From: Stephen Thorpe [REDACTED]
Sent: 05 May 2020 10:27
To: Daun Johnson <Daun.Johnson@arun.gov.uk>
Subject: RE: Request for further information BR/87/20/PL

block plan
1:200

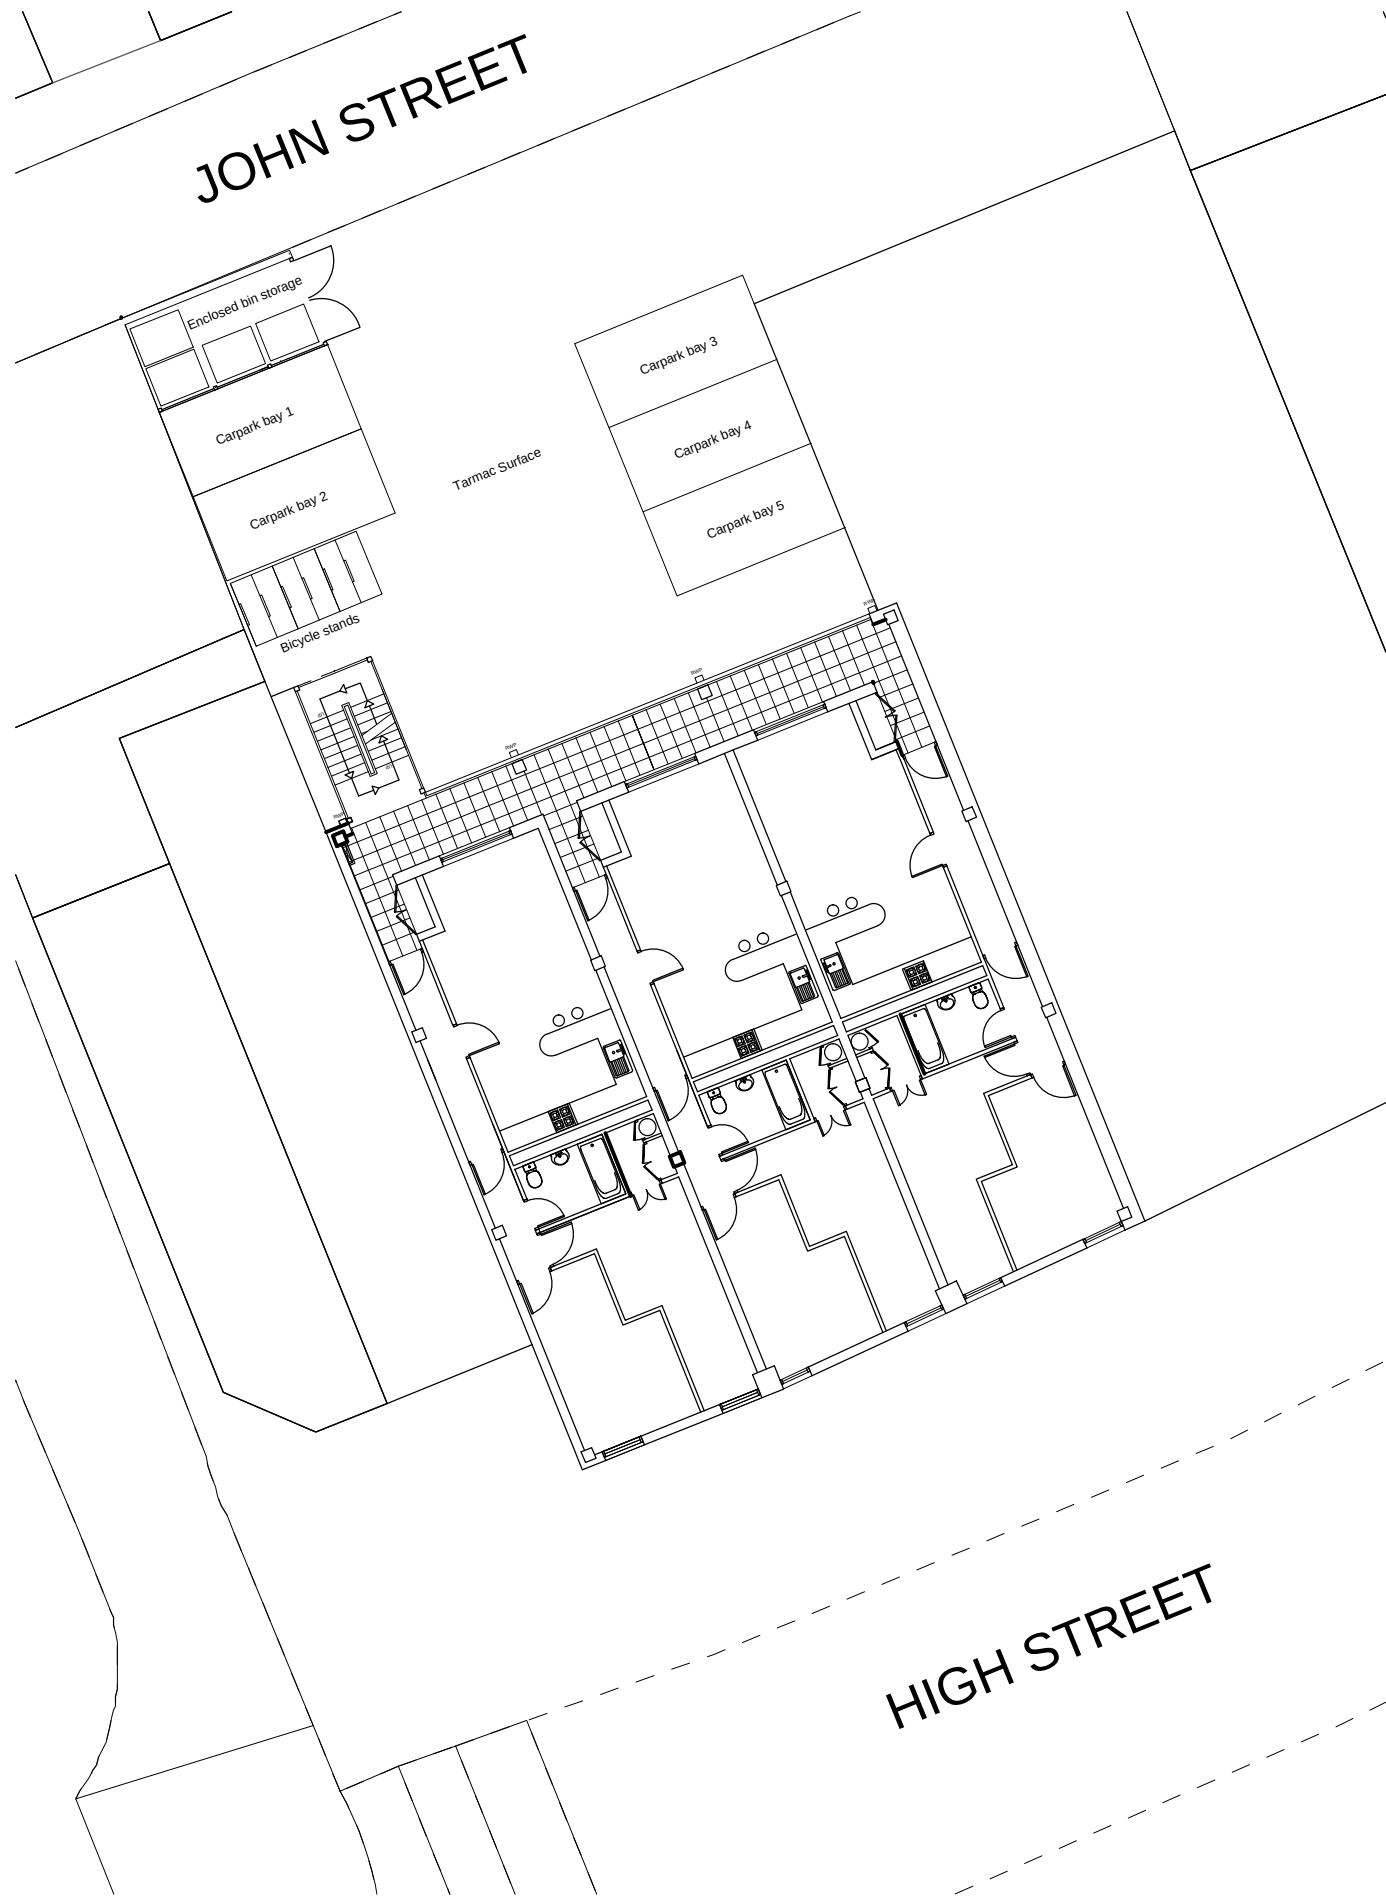
Also, on the block plan can you please clearly highlight the position of the new security shutters. You may draw an arrow and annotate the new shutter doors or you may use a different colour, besides black to clearly highlight the new shutter doors.

I don't have access to CAD at present due to the current situation but the shop front shutters are being installed on the front elevation (dwg provided) facing the High Street as marked on the site plan.
